East Anglia ONE North and East Anglia TWO Offshore Windfarms

Applicants' Comments on the Environment Agency's Deadline 9 Submission

Applicant: East Anglia TWO and East Anglia ONE North Limited
Document Reference: ExA.AS-10.D10.V1
SPR Reference: EA1N_EA2-DWF-ENV-REP-IBR-001060

Date: 6th May 2021
Revision: Version 1
Author: Royal HaskoningDHV

## Appendix 2: SuDS Outfall Concept Design to the Friston Watercourse

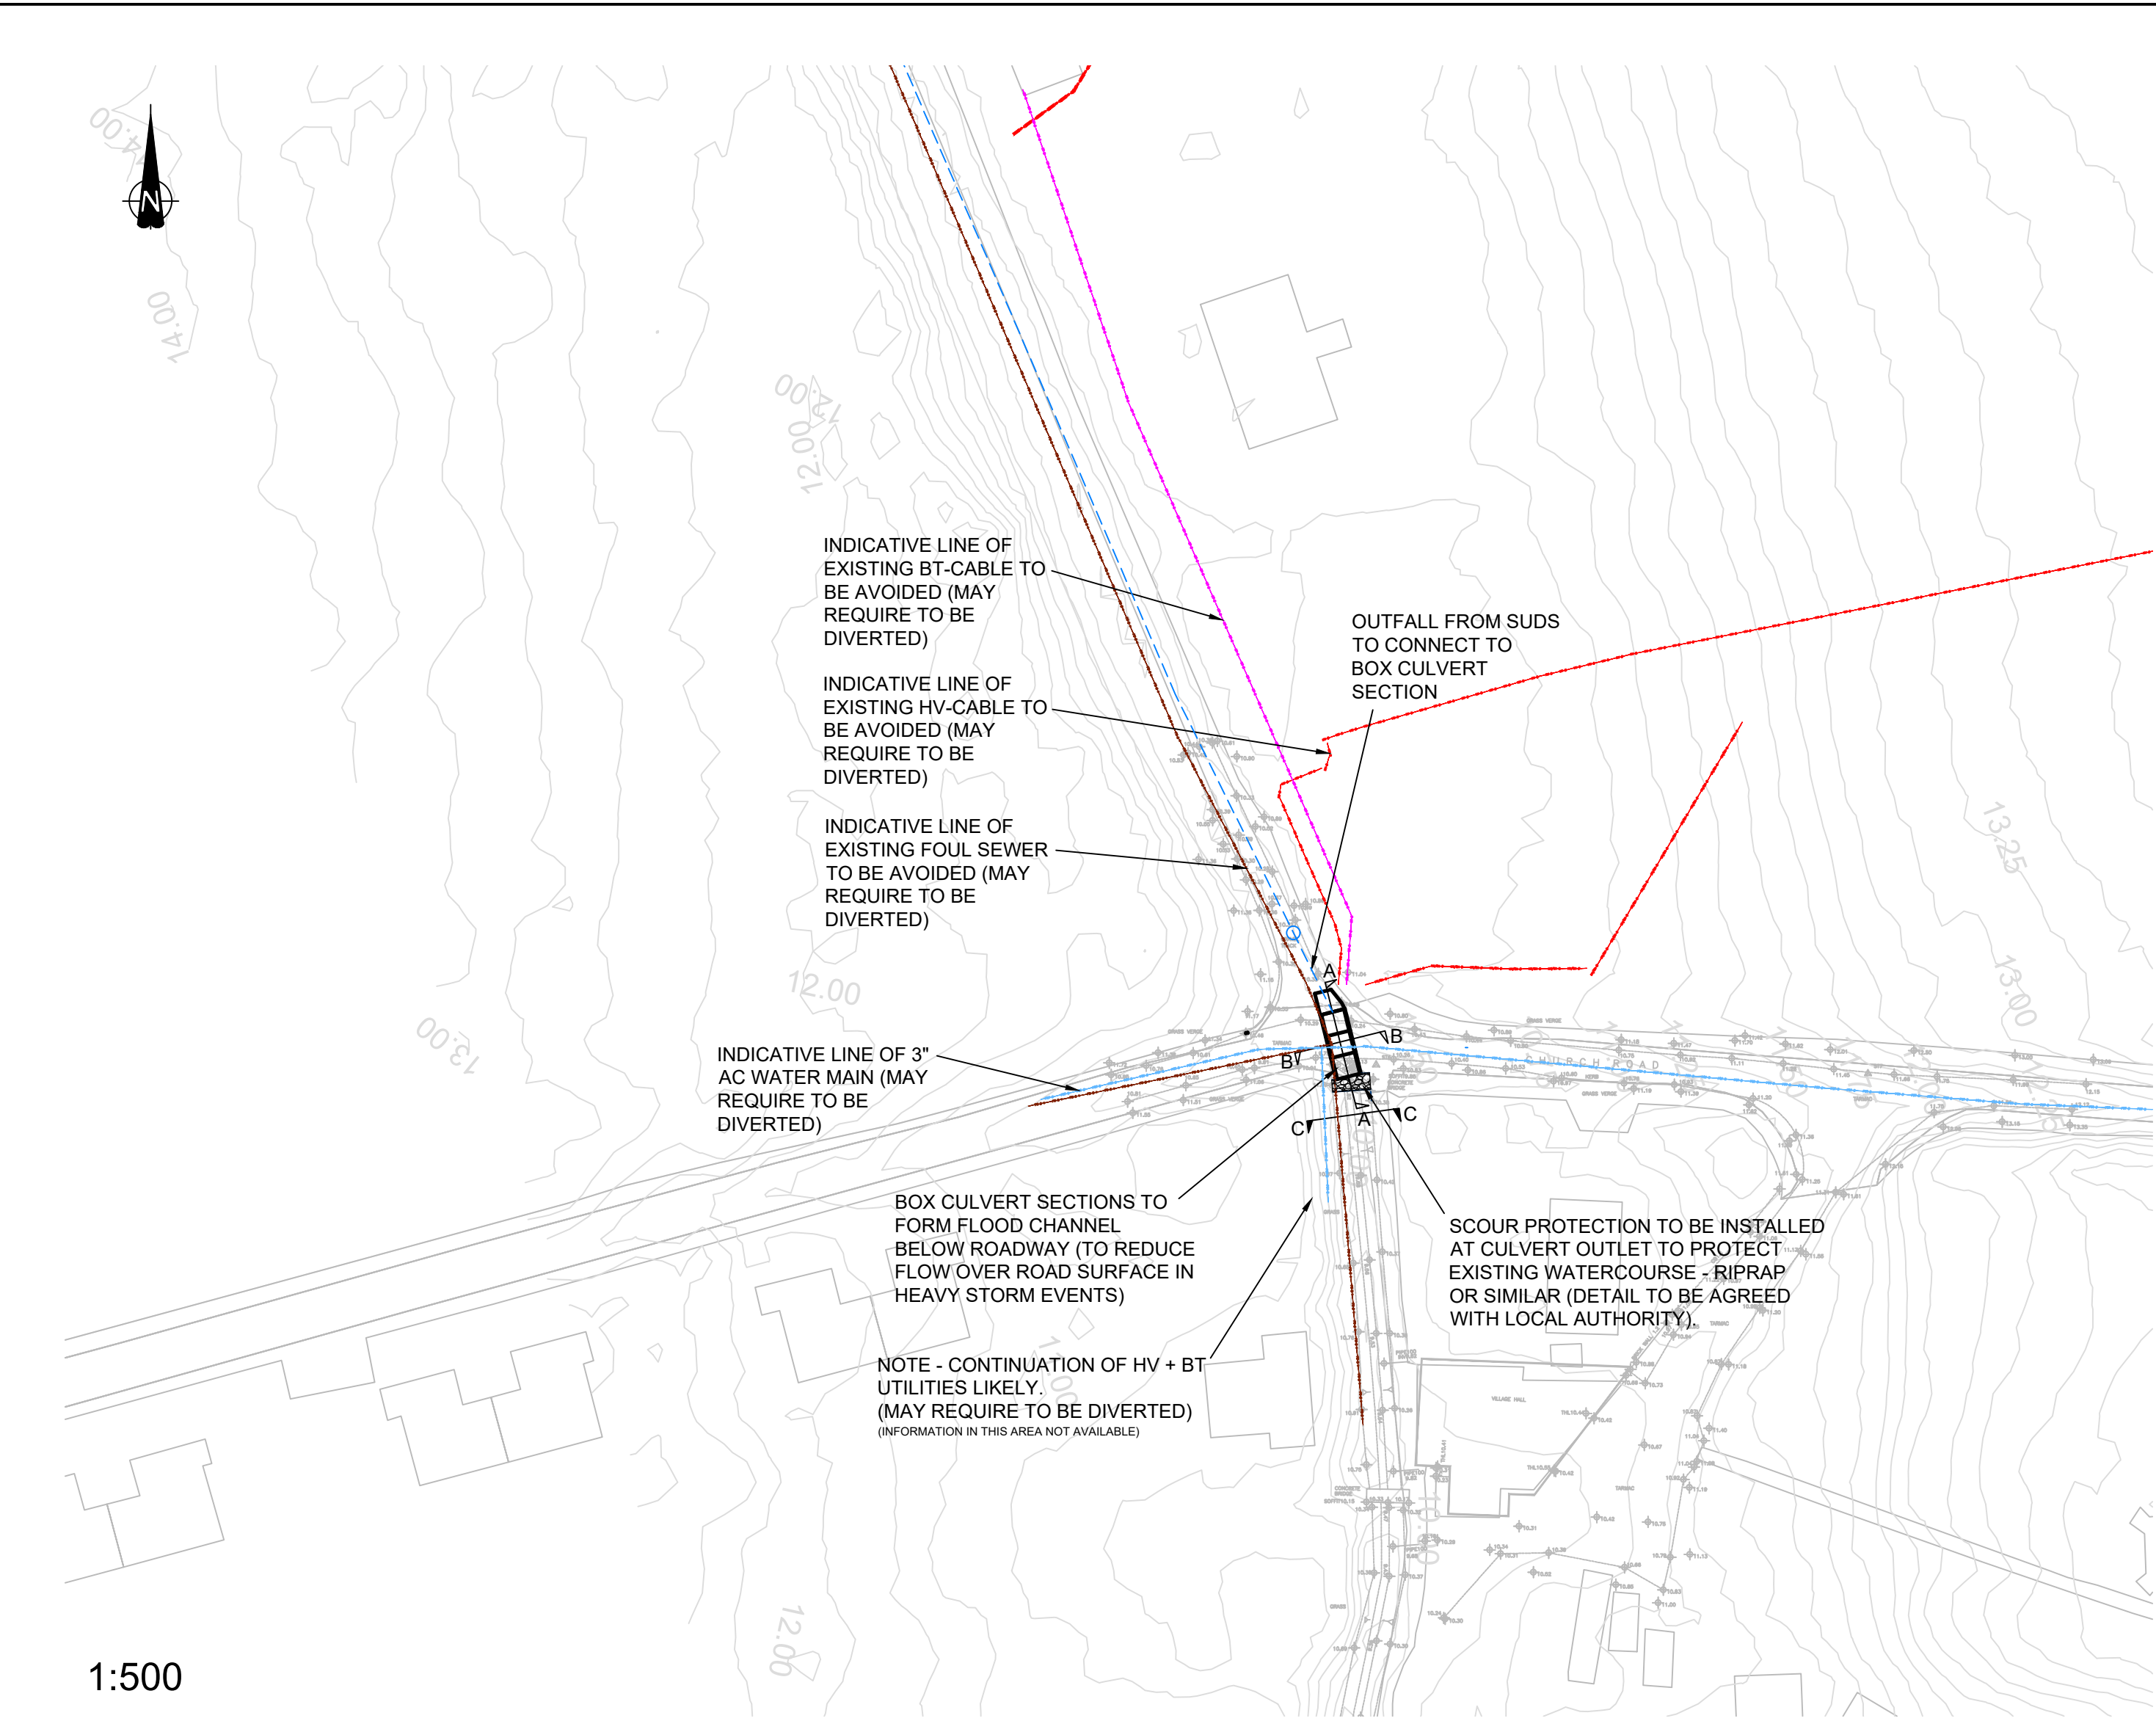
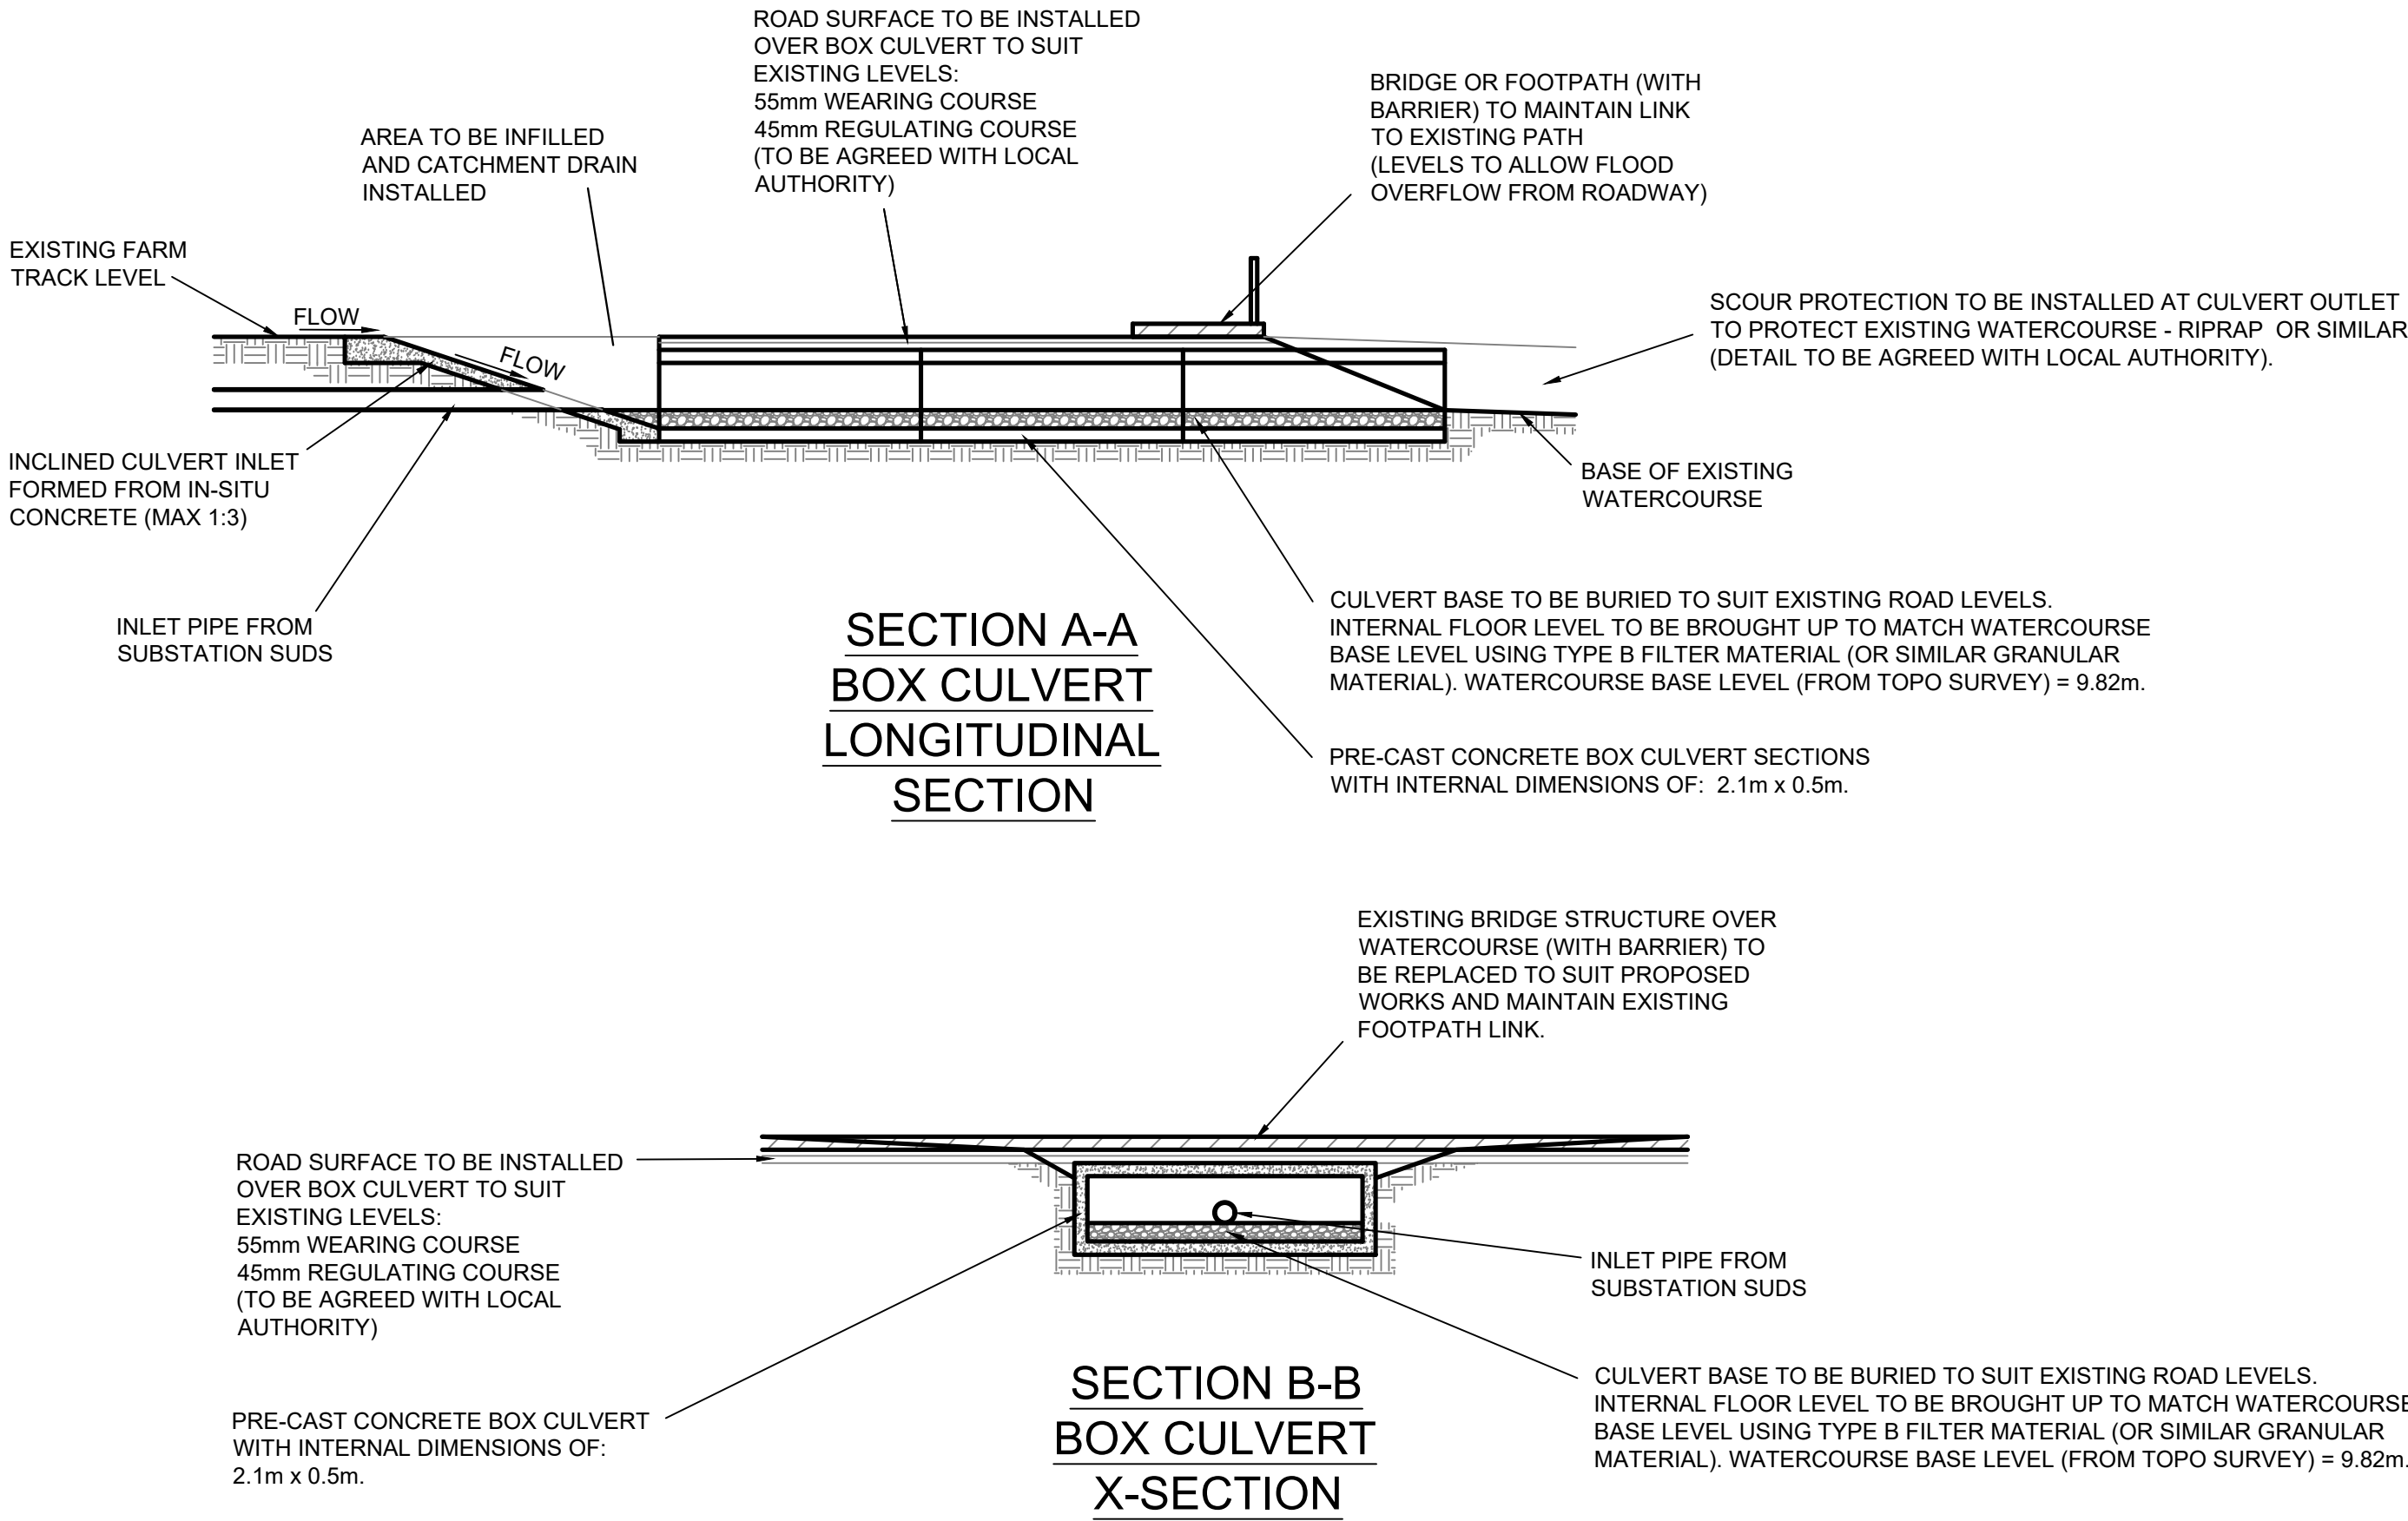
Point	Environment Agency Comment	Applicants' Response
Outline Operational Drainage Management Plan		
1	We have reviewed the Outline Operational Drainage Management Plans (OODMP) submitted at Deadline 8, for both EA1N and EA2 (both Doc. Ref. ExA.AS-3.D8.V4, both dated 25 March 2021).	Noted.
2	We note the addition of Plate 3 and Appendix 2 in each document, which provide some detail for a box culvert and pipe connection to Friston Watercourse, if required. We also note the inclusion of paragraph 139, which states that maintenance of the operational drainage scheme will be secured through the final Operational Drainage Management Plan.	Noted.
3	As discussed within the OODMP documents, it will be essential to ensure that flood risk is not increased as a result of any positive discharge to Friston Watercourse. The Lead Local Flood Authority must be satisfied with the proposed rate of discharge.	<p>The Applicants would like to clarify that design of the sustainable drainage system (SuDS) and the option progressed will prioritise the use of infiltration subject to ground conditions (informed by infiltration testing) and the site specific hydraulic model, thereby minimising the requirement for a positive drainage connection as part of the surface water drainage scheme to the Friston Watercourse.</p> <p>However, should there be a need to include a positive discharge to the Friston Watercourse, the Applicants have committed to not exceeding the pre-development Q_{BAR} runoff rate within the Outline Operational Drainage Management Plan (OODMP) (REP8-064), which is secured by Requirement 41 of the draft Development Consent Order (DCO) (document reference 3.1). This has been agreed within the Statement of Common Ground (SoCG) (REP8-114) with Suffolk County Council, who are the Lead Local Flood Authority.</p>

Point	Environment Agency Comment	Applicants' Response
		<p>As the Friston Watercourse is a Main River at this location the Applicants will undertake consultation with the Environment Agency to confirm connection, permitting and maintenance requirements during detailed design.</p>
4	<p>Friston Watercourse currently receives a significant amount of silt, contained within the surface water run-off entering the channel from the Church Road and Grove Road areas. Therefore we would just highlight at this stage that the final SuDS scheme should be designed to ensure that the sediment load entering Friston Watercourse is not increased as a result of the proposed development, and is decreased where possible. The final design of any positive outfall should seek to minimize the risk of blockage as a result of sediment build up in the channel. In preparing the final Operational Drainage Management Plan, the need for any on-going maintenance to ensure that the outfall remains operational and able to discharge throughout the lifetime of the development should be considered. We would need to review and approve any maintenance activities within the channel.</p>	<p>The Applicants note that the Environment Agency agree that the detail of silt control is a matter which should be dealt with at the time of final design. A review of the silt removal measures will be carried out in accordance with CIRIA C753 SuDS Manual (CIRIA, 2015) during detailed design.</p> <p>The development of the Projects' substations will change land use within part of the catchment which will prevent a significant portion of sediment from entering the Friston Watercourse compared to the pre-development silt loading. Therefore there will be a reduction in the silt levels (all things being equal) as a result of the Projects.</p> <p>Where an attenuation only, or a hybrid solution is adopted, the SuDS pond itself and the upstream/downstream pipework system will prevent a significant portion of sediment from entering the Friston Watercourse compared to the pre-development silt loading. This is due to the SuDS pond acting as a settlement pond, removing sediment prior to it entering the discharge pipe and subsequently the Friston Watercourse. Any siltation within the SuDS pond will then be regularly removed by the Applicants as part of its continuous SuDS maintenance activities.</p> <p>If increased maintenance of the Friston Watercourse is required then the Applicants are committed to undertake this until the Projects are decommissioned, also detailed in the OODMP (REP8-064) and Requirement 41 of the draft DCO (document</p>

Point	Environment Agency Comment	Applicants' Response
		reference 3.1). As the Friston Watercourse is a Main River at this location, the Applicants will undertake consultation with the Environment Agency to confirm connection, permitting and maintenance requirements during detailed design.
5	Consideration of these issues will form part of our assessment of the final Operational Drainage Management Plan, under Requirement 41.	Noted.
